Please ask for: Nicola Moore
Email: nicola.moore@arun.gov.uk
Telephone: Ext 37944
Our Ref: FG/5/21/HH
Your Ref:
Date: 21st January 2021

Application for Planning Permission for Works or Extension to a Dwelling

Development: Removal of existing single garage, new single storey side extension with part pitched roof and main area of flat roof
Location: 4 Chalet Gardens Ferring BN12 5PD

DRG • 21 / 02/5
SCALE • 1/100 M.
DATE • JAN: 2021.

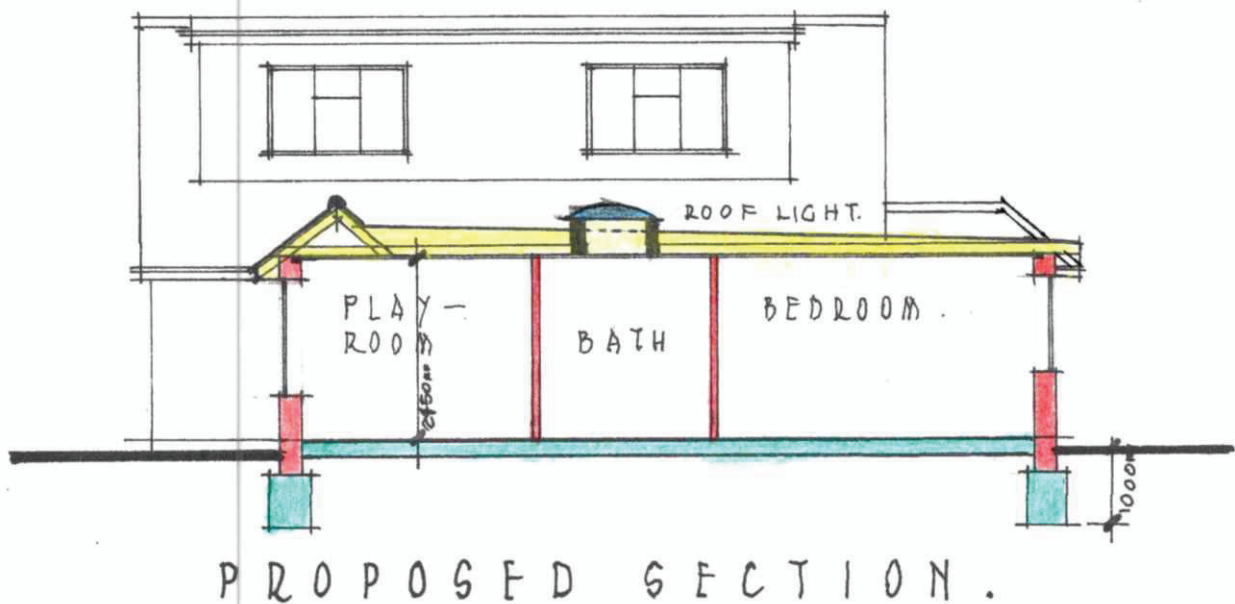
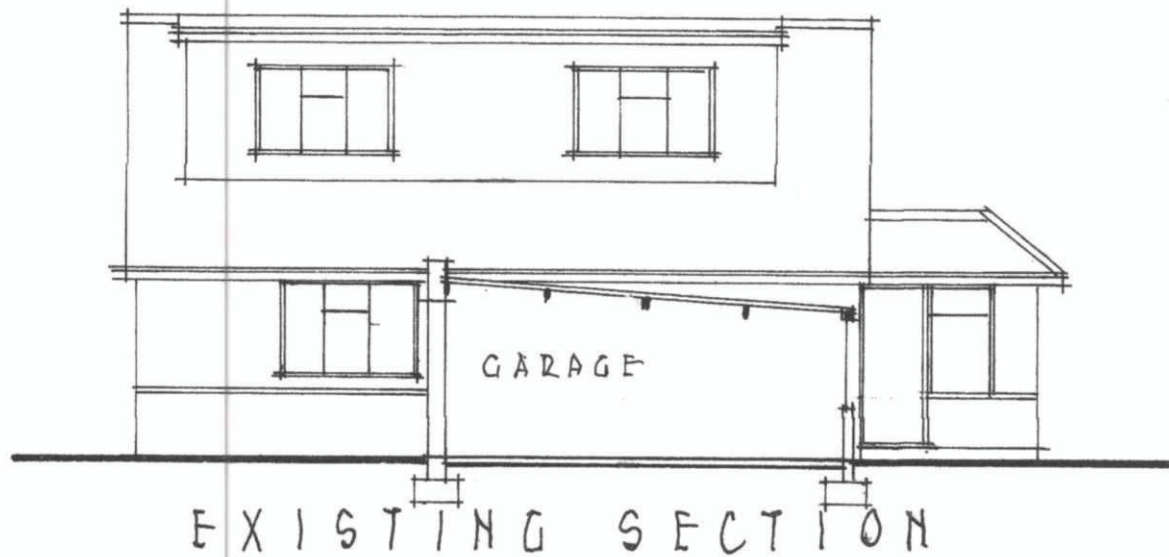
Block Plan

Please amend the Block Plan to show written measurements to boundaries and re submit.
